From: Sarah Burrow <Sarah.Burrow@arun.gov.uk>
Sent: 17 August 2021 15:54
To: Planning.Responses <Planning.Responses@arun.gov.uk>
Cc: Amber Willard <Amber.Willard@arun.gov.uk>
Subject: RE: Planning Consultation on: AL/93/21/HH

Engineers Comments Regarding Surface Water Drainage

Application No: AL/93/21/HH
Registered: 9th July 2021
Site Address: 23 Olivers Meadow Westergate PO20 3YA
Grid Reference: 493785 105162
Description of Works: 2 storey side extension

Drawing: PROPOSED

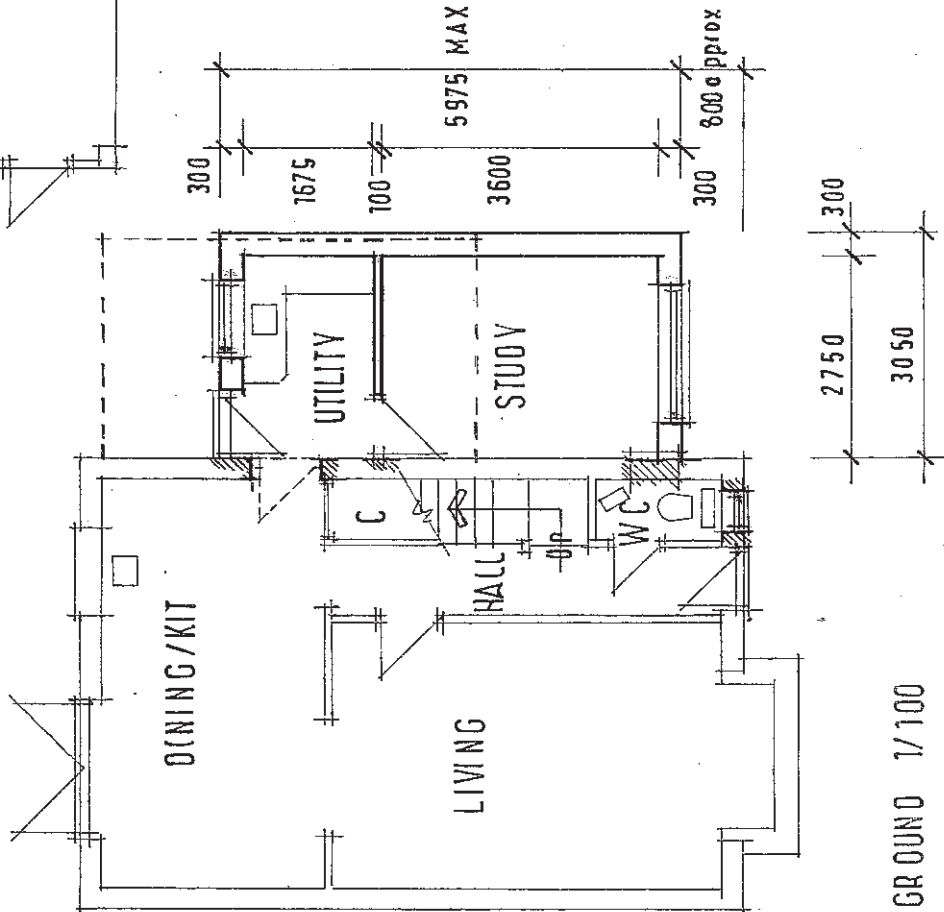
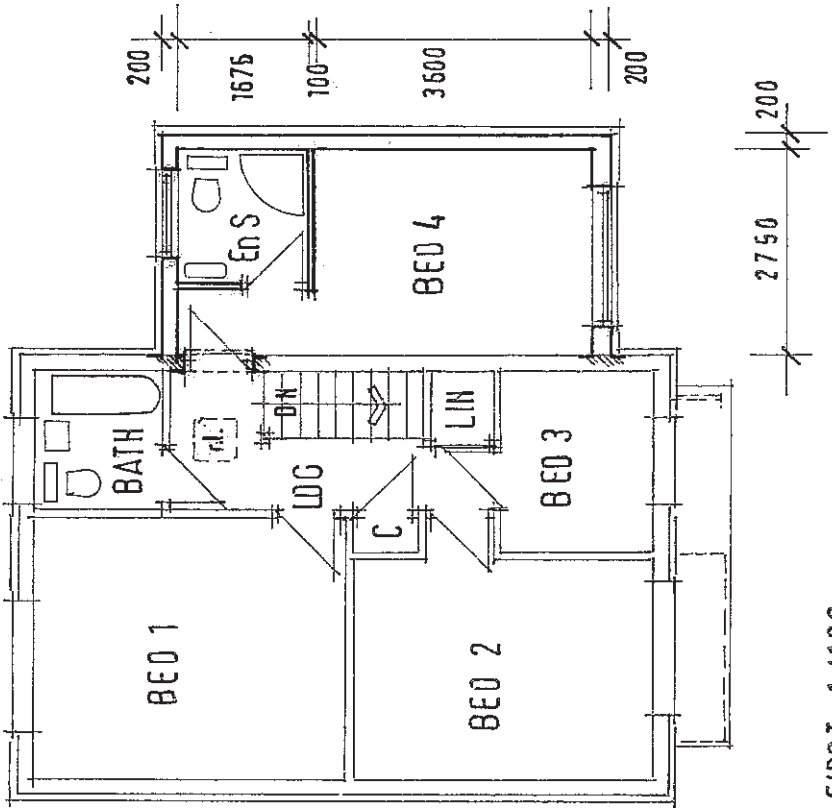
Our mapping shows a foul water sewer running directly underneath the proposed extension, therefore I would expect Southern Water to be consulted as they may request conditions relating to easements, build over agreements or diversions.

Scale 1:500 @ A3
Block Plan

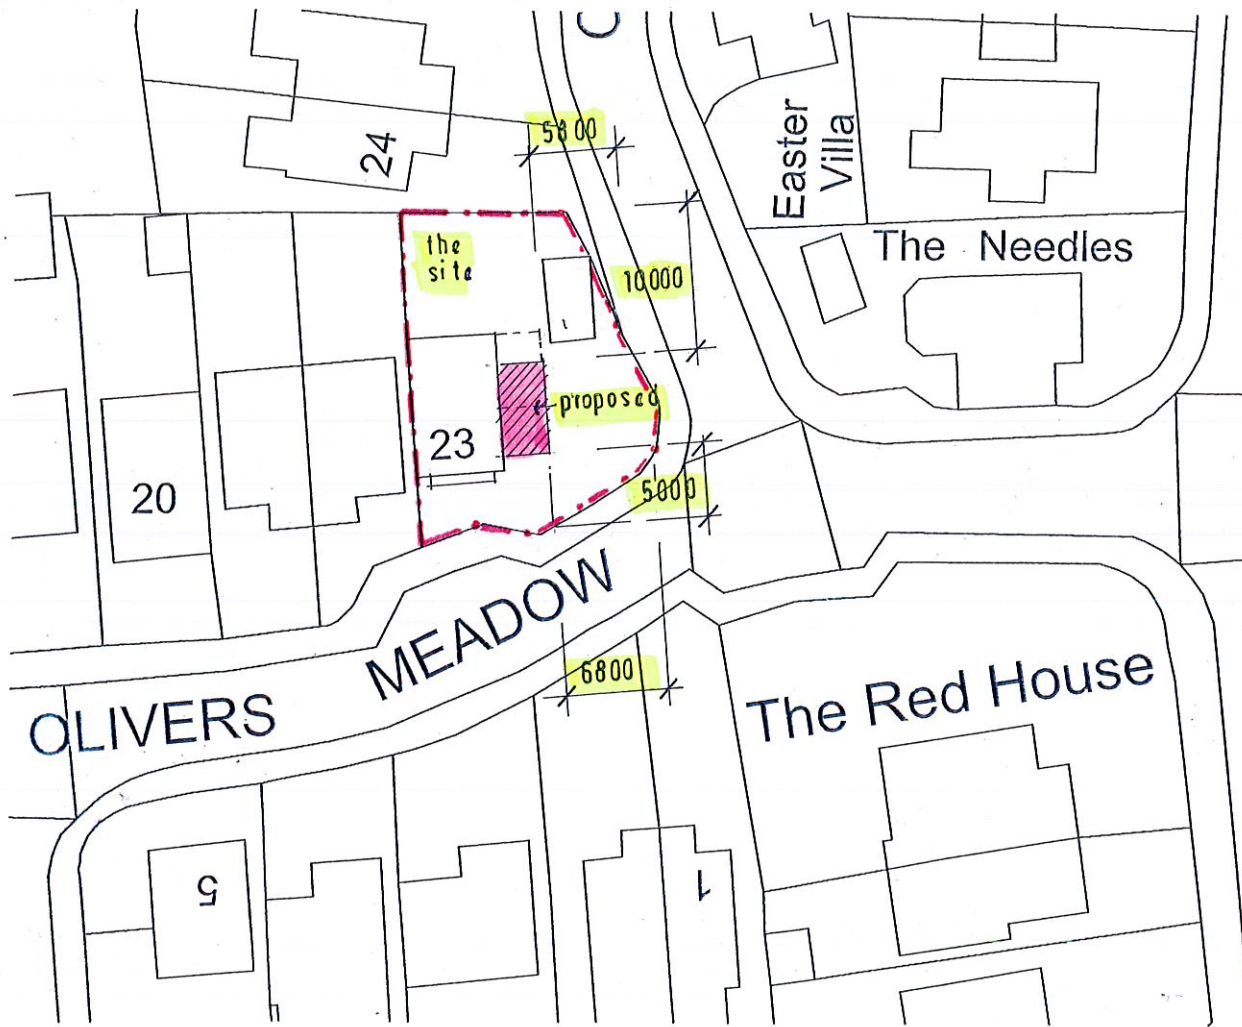
The application is within the Lidsey Treatment Catchment, therefore surface water drainage design should be carefully considered. Infiltration must be fully investigated.
